MEMORANDUM

DATE: April 13, 2021

SUBJECT: PUDSP-20-005 – Falcon Meadows at Bent Grass (with EGP)
Third Submittal

Engineering Division

**C2.2**  
Sheet 7 of 12

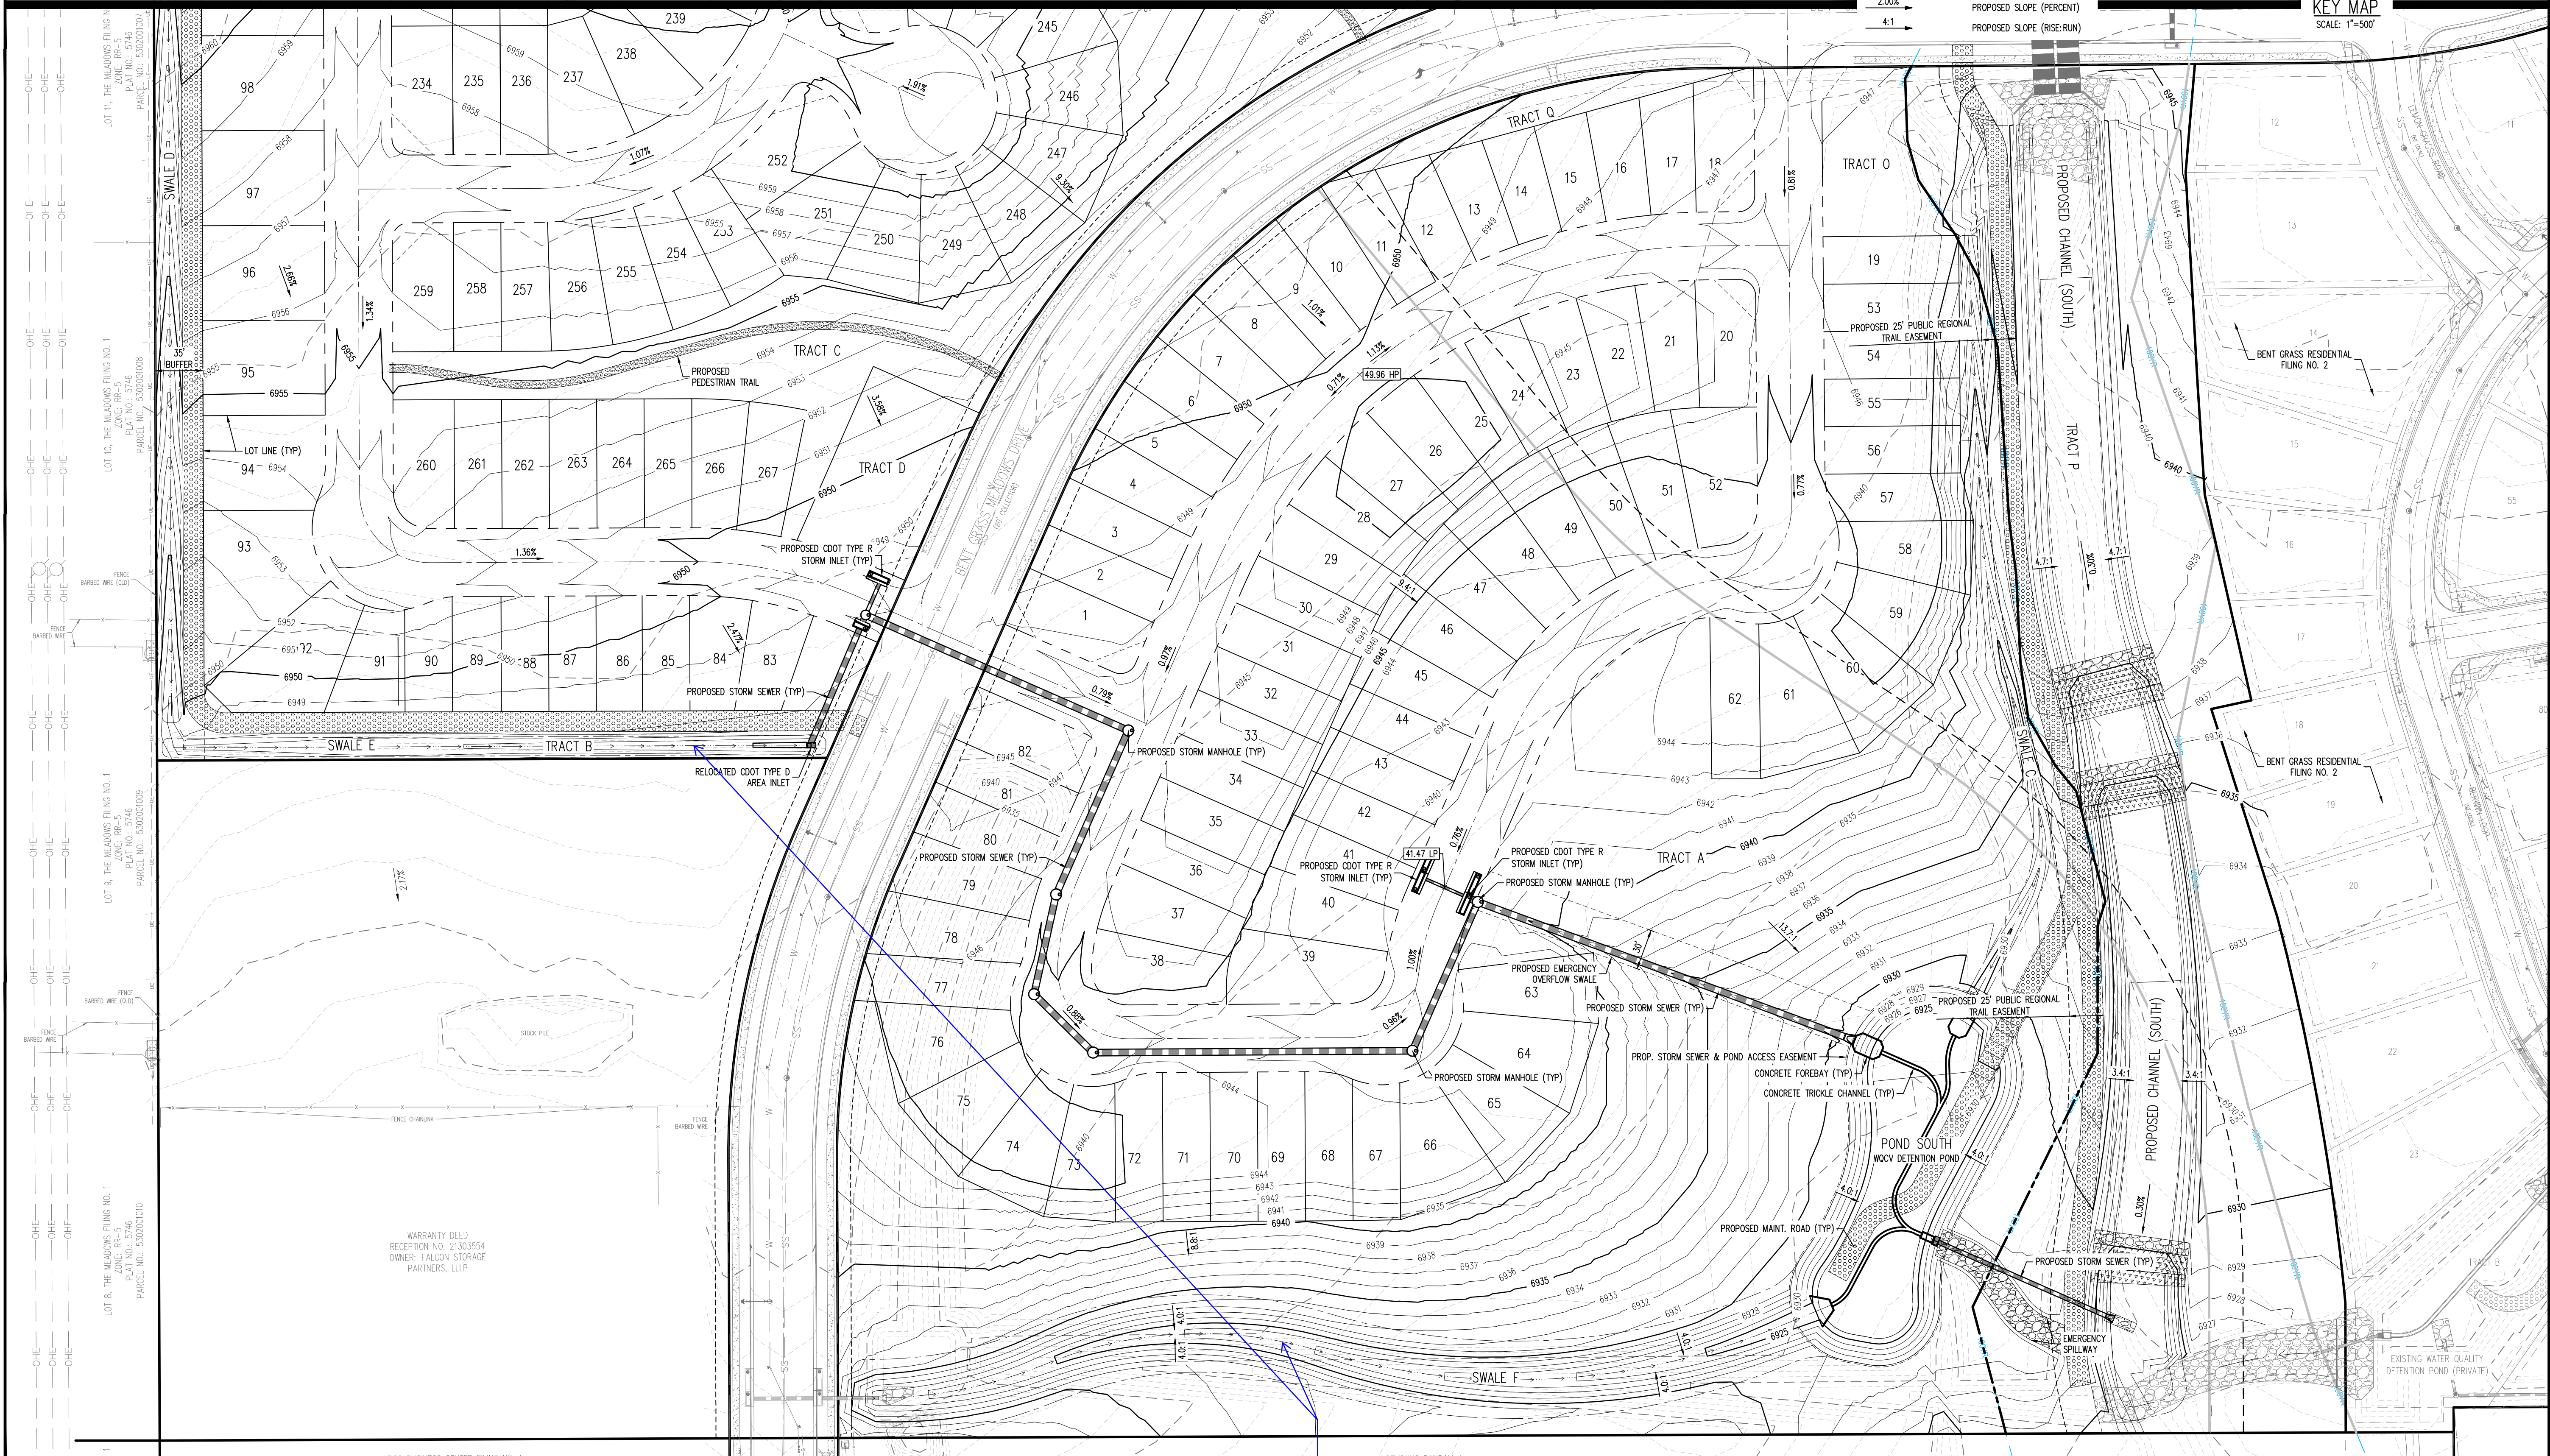
6. Provide a statement that all proposed developed areas will be treated by the WQCV ponds or describe any areas that won't be and show those areas on a separate WQVV/MS4 plan. **(see redlined plan)** **Unresolved** – the statement was made but this is not reflected on the drainage plans. **There is still a developed area proposed not to be treated; it does not appear that there is justification for this (see redlines).**

Response: If swale is built at back of lots, there is not room for a swale and maintenance access and lots to grade appropriately. If swale is built, there would be no maintenance access to the swale.
